12/692

8 Fordwich Road
Welwyn Garden City
Herts
AL8 6EY

I live at 8 Fordwich Road and my neighbours at 6 Fordwich Road have submitted a planning application. These are my comments on that.

**DRAWING TITLE**  
PROPOSED SINGLE STOREY SIDE  
AND REAR EXTENSIONS

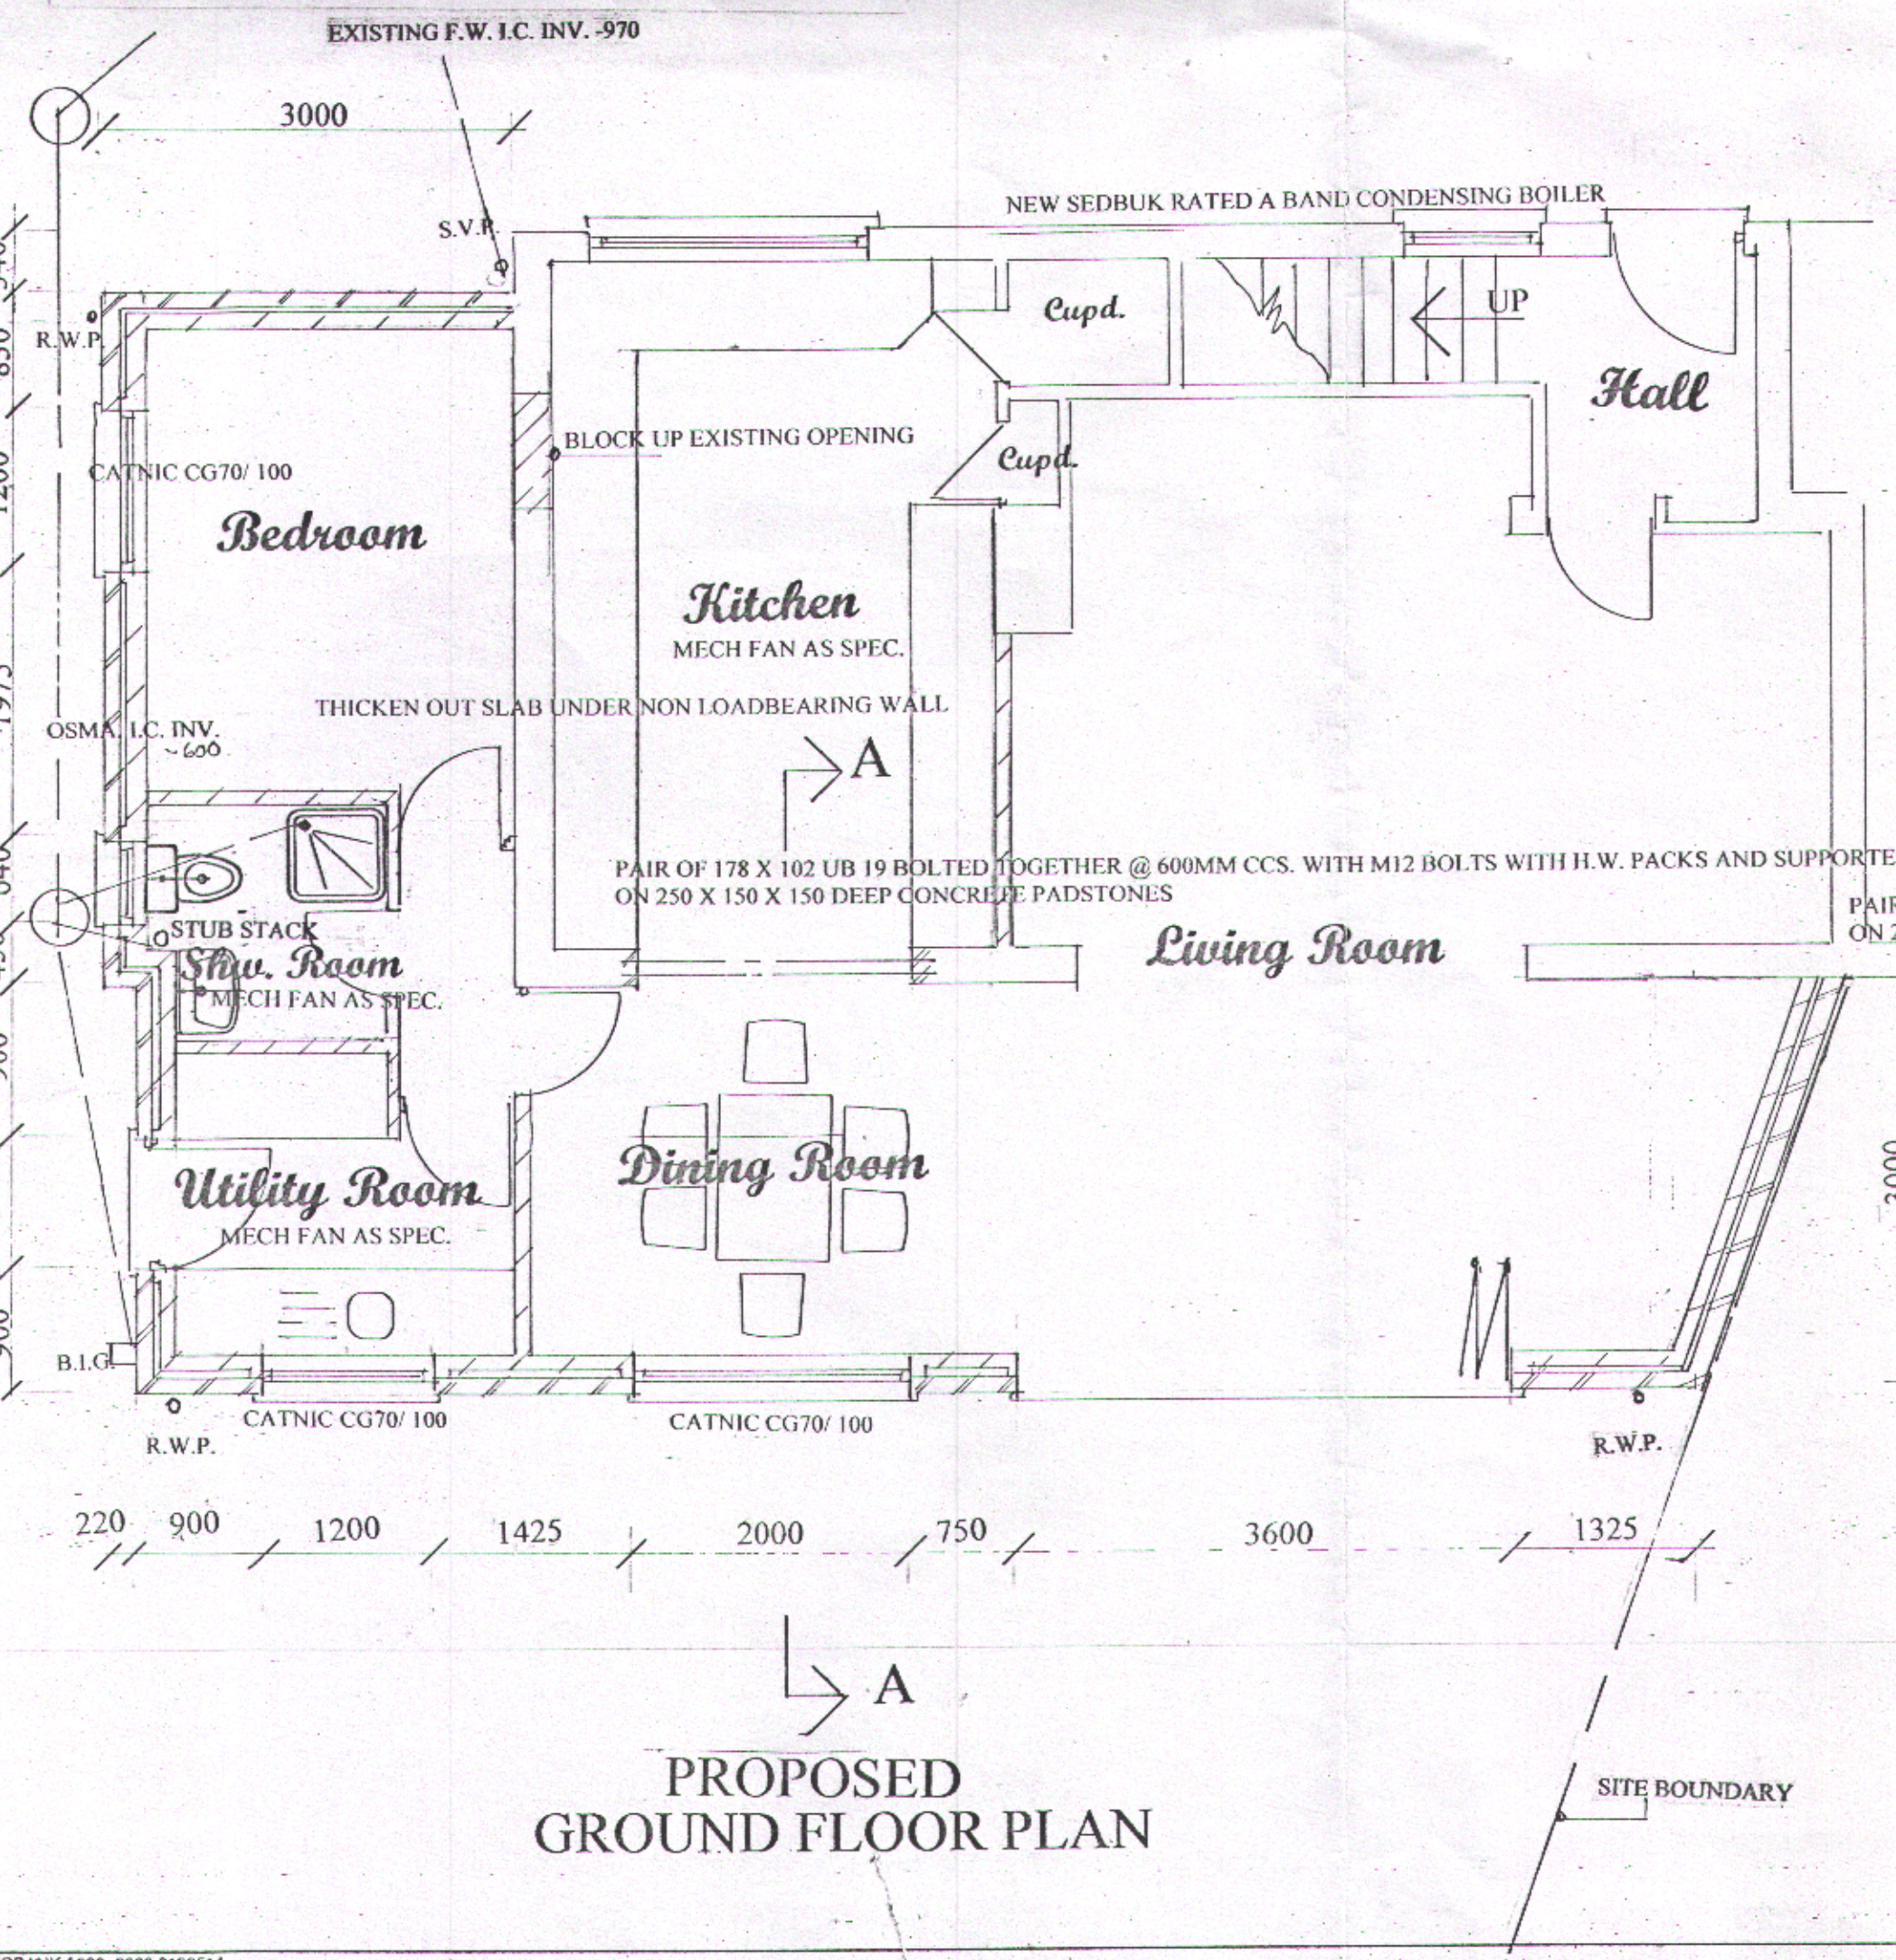
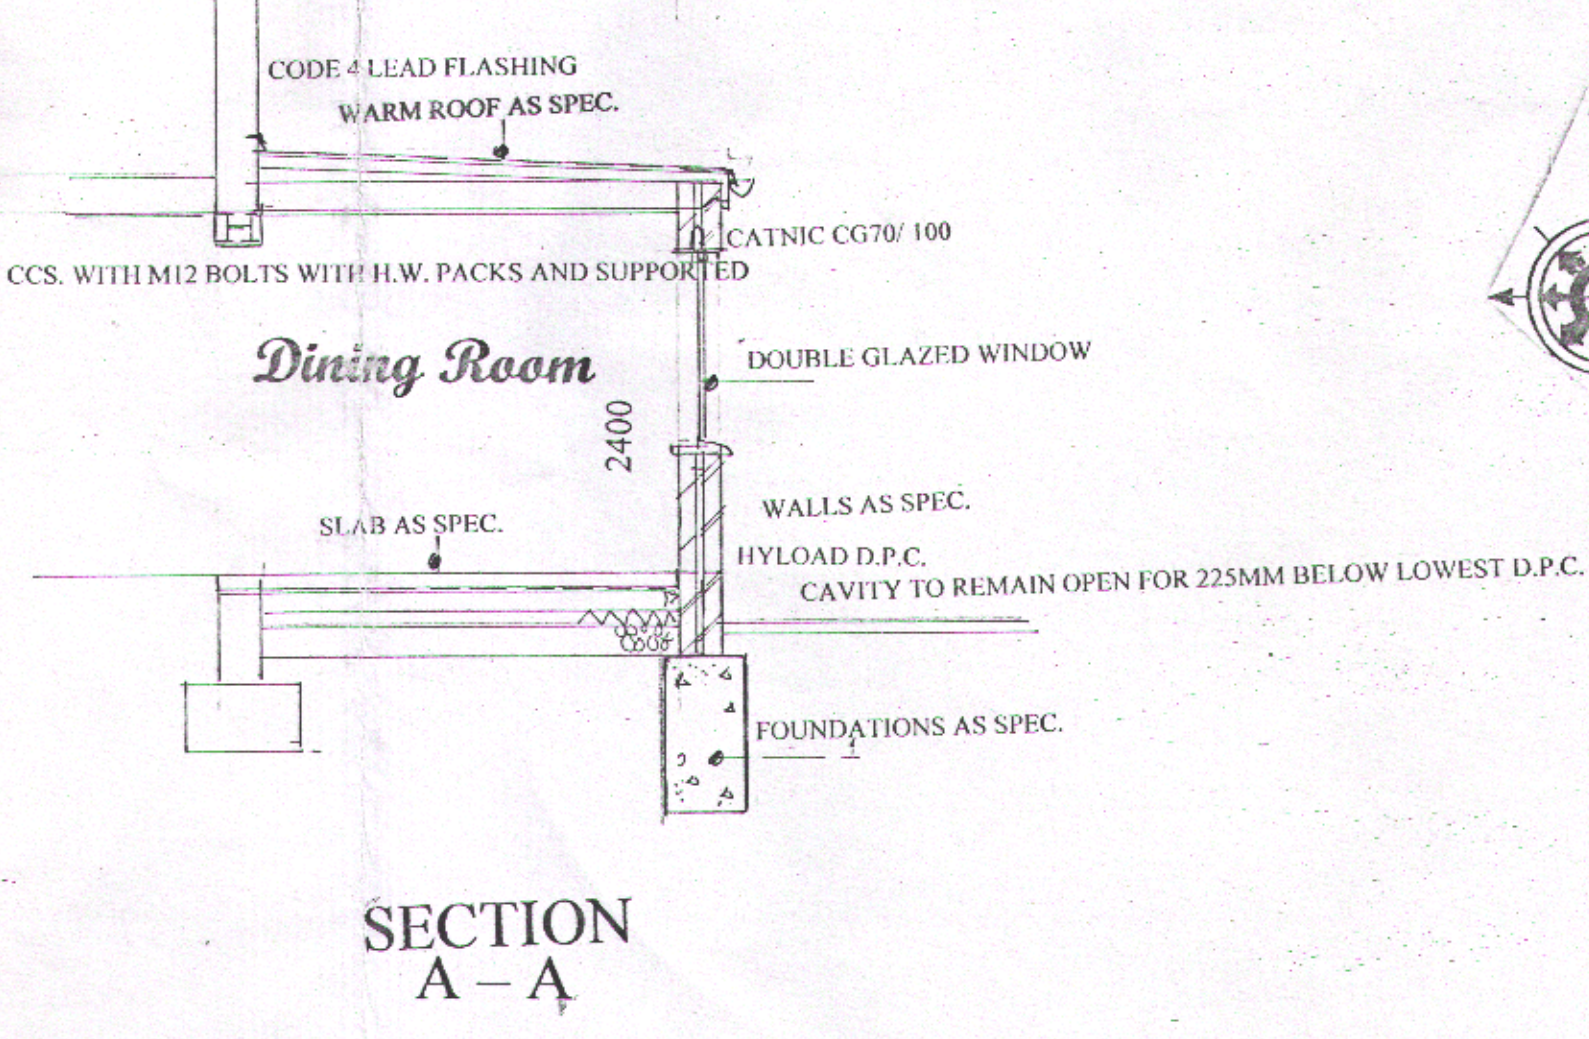
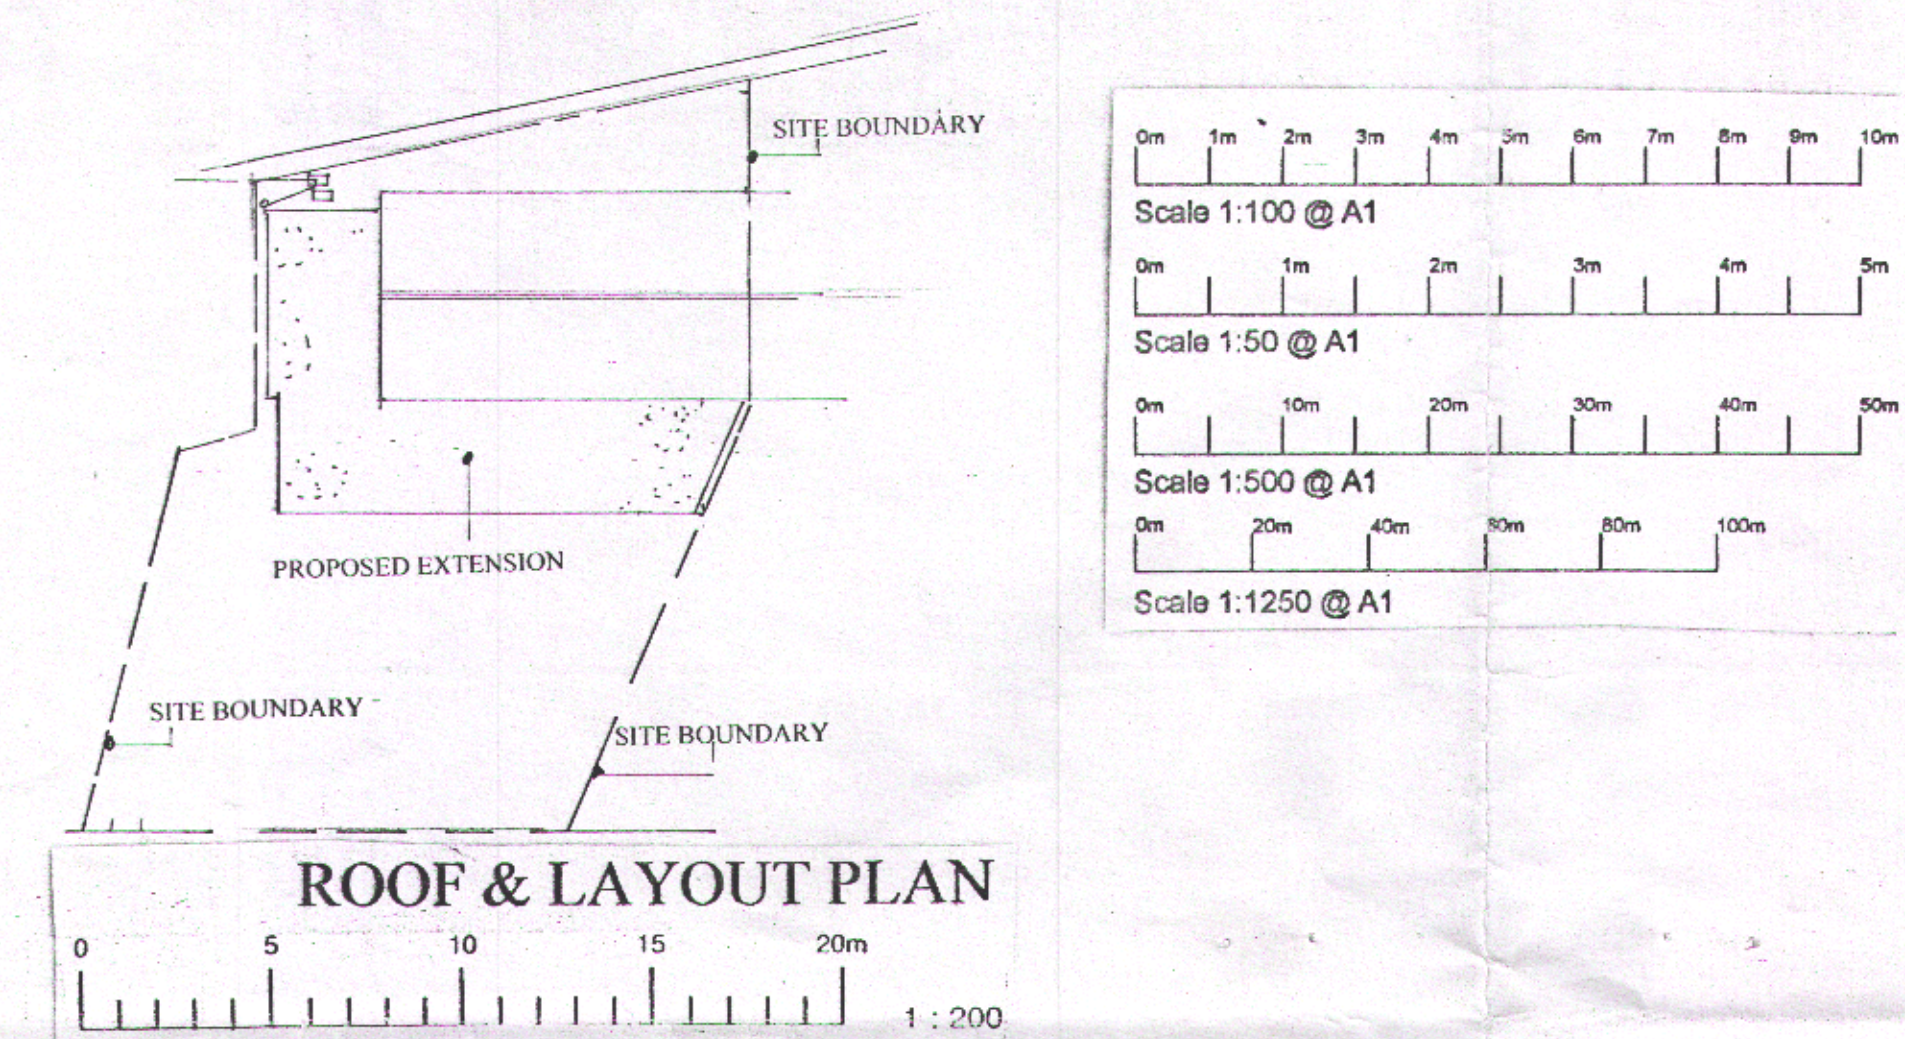
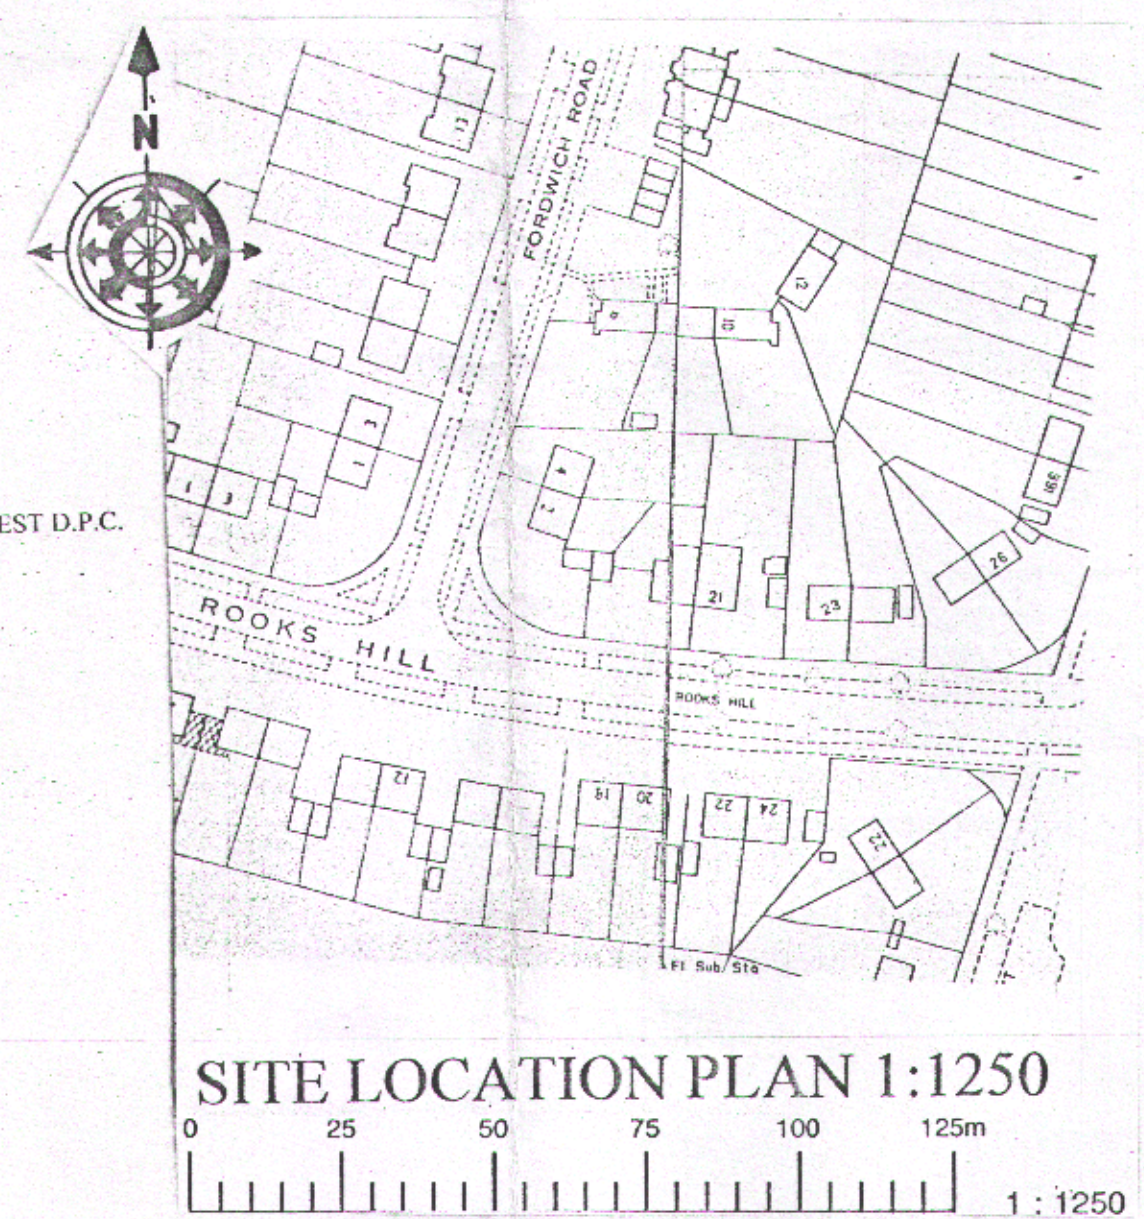
I would say in general that an extra bedroom would mean that parking and security arrangements should be given more thought than they have been offered in these plans. Also, I think a section of the extension is close to the party wall and I would like to give this further consideration. I also need to look again at the arrangements for access and how this would affect the side access point for 6 Fordwich Road, which provides an additional access point to the accommodation.

Any extension to the property should take these into account. Finally the piano playing has in the past disturbed the sleep of the residents of 8 Fordwich Road, and some attention should be given to sound-proofing while there are general works being undertaken to the living room.
